**FINAL DRAINAGE REPORT FOR
BRANDING IRON AT STERLING RANCH
FILING NO. 1**

November 2017

Project #09-006
DSD Project # **SF-17-024**

LEGEND

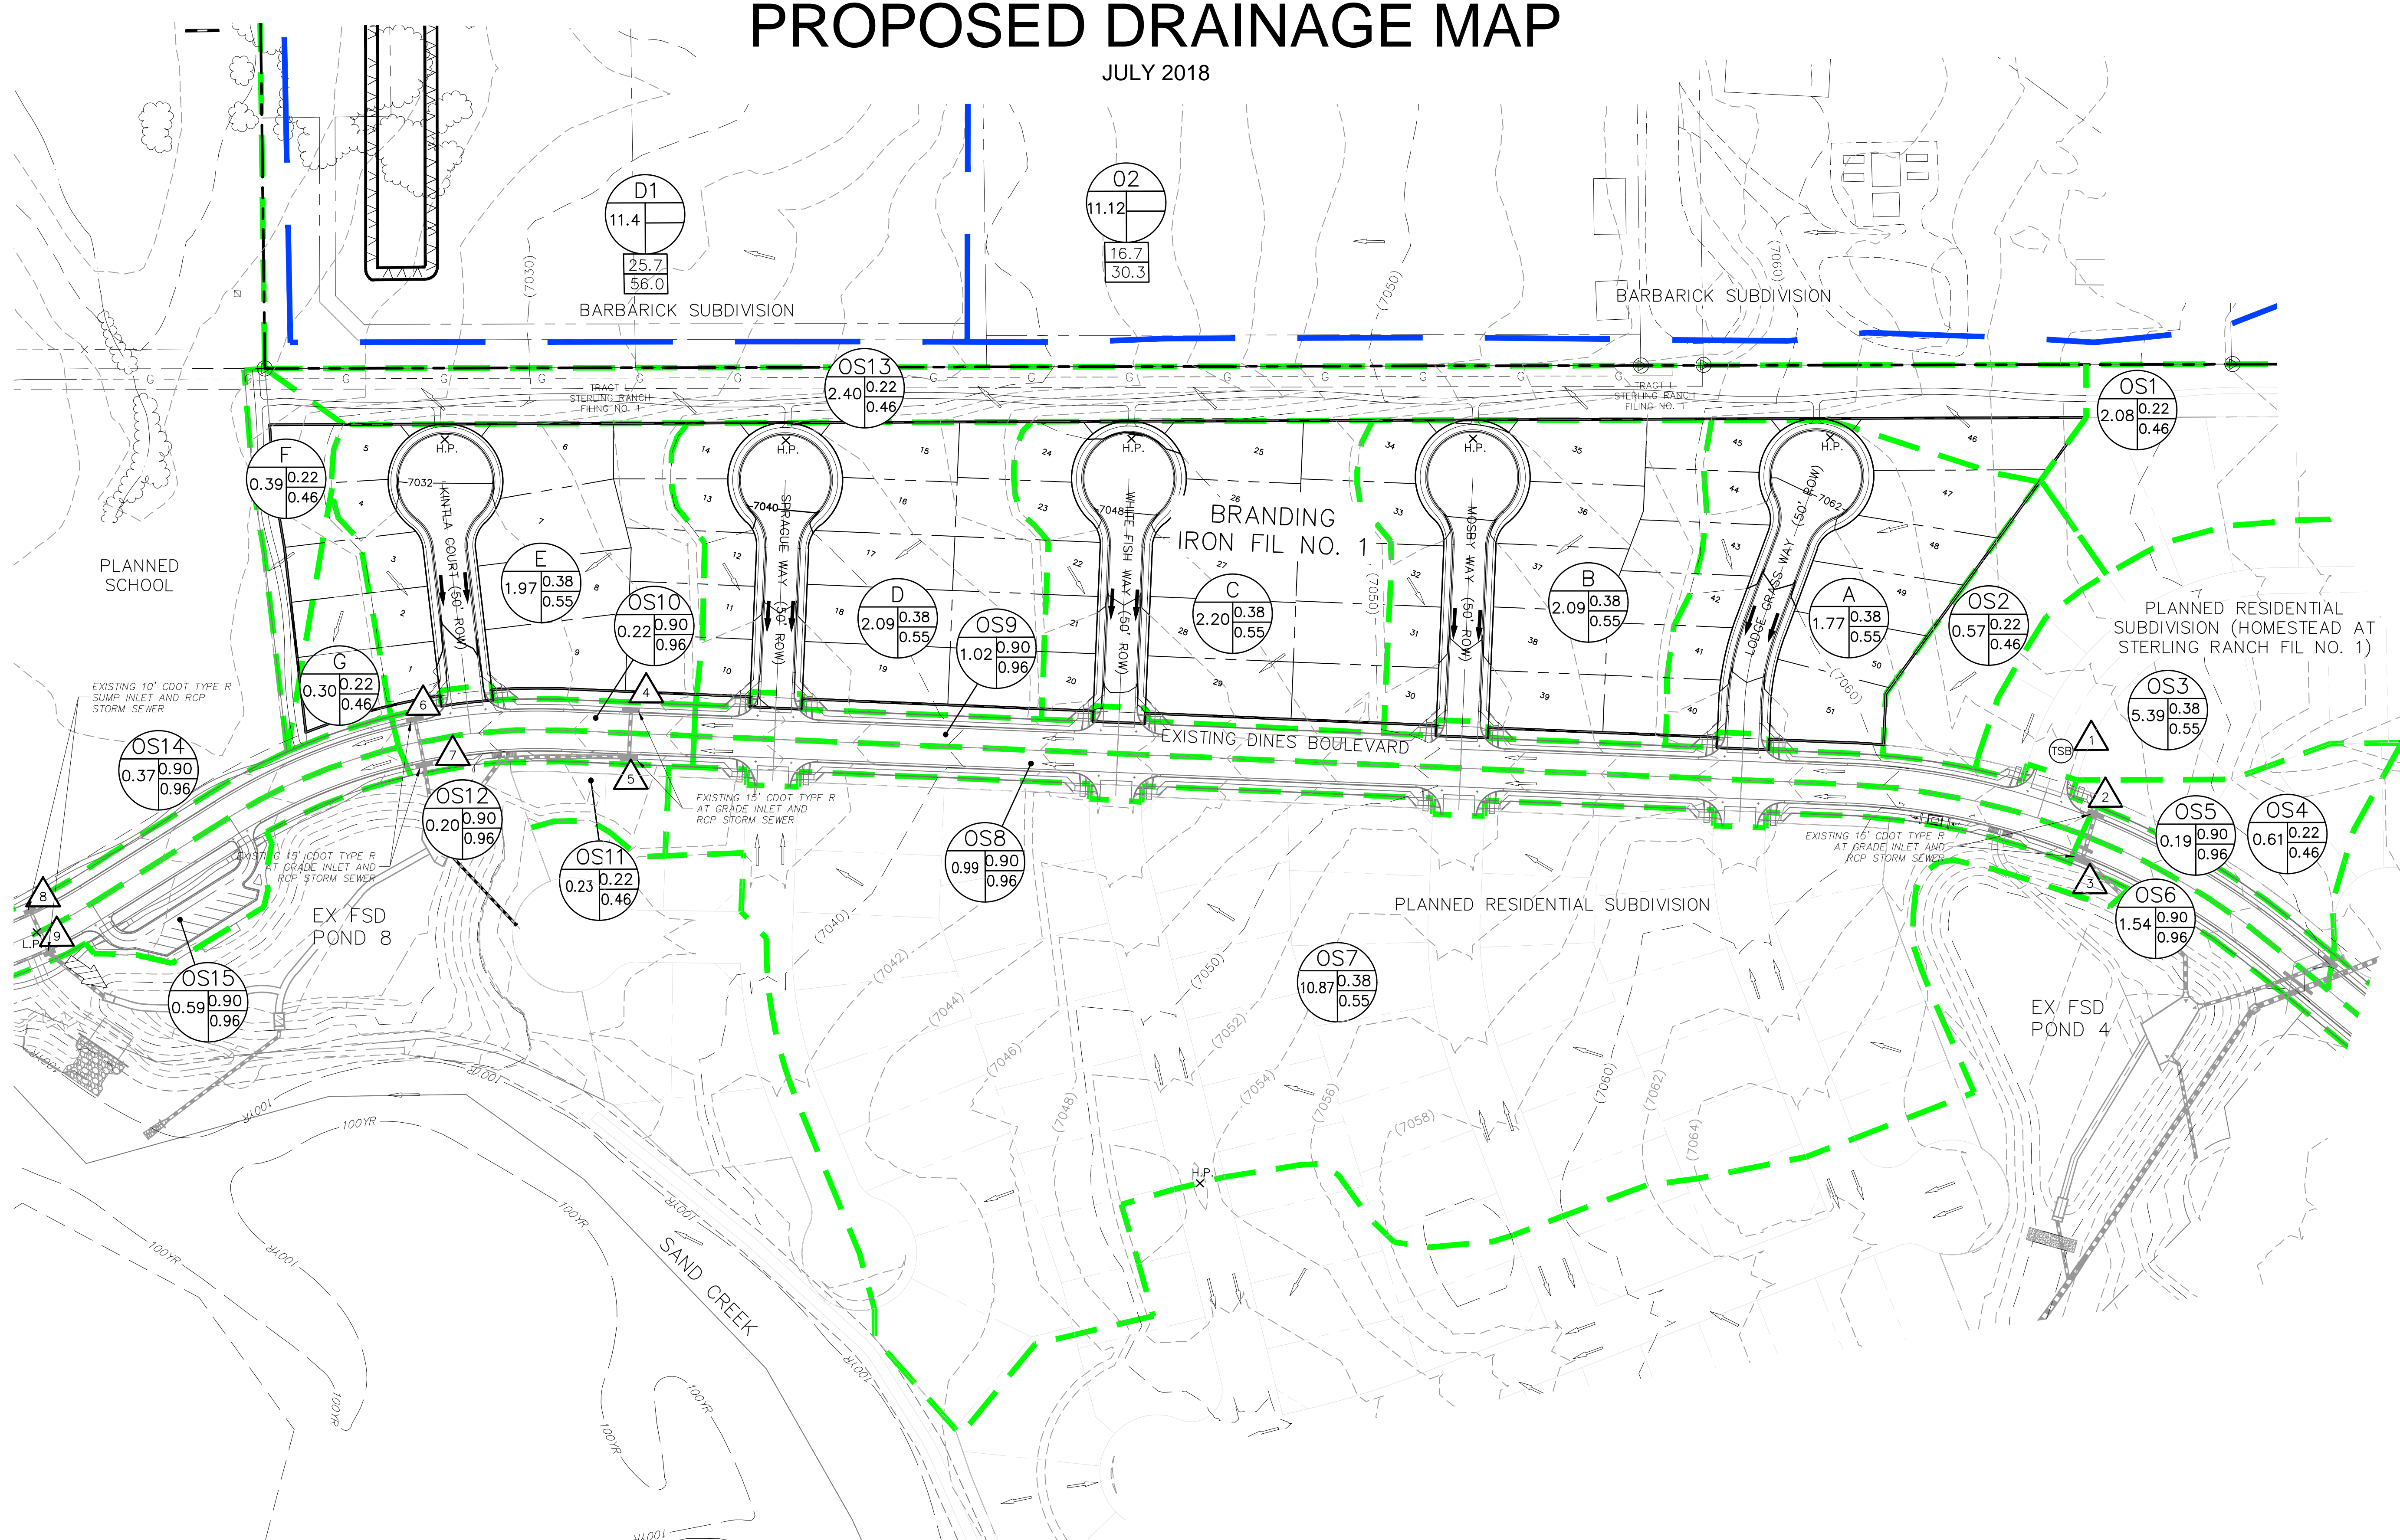
How and where is this flowby conveyed in the interim conditions? (DP7 also)

Address WQCV (see comment letter)

Address downstream full-spectrum facilities, to be constructed with S.R. Filing 1.
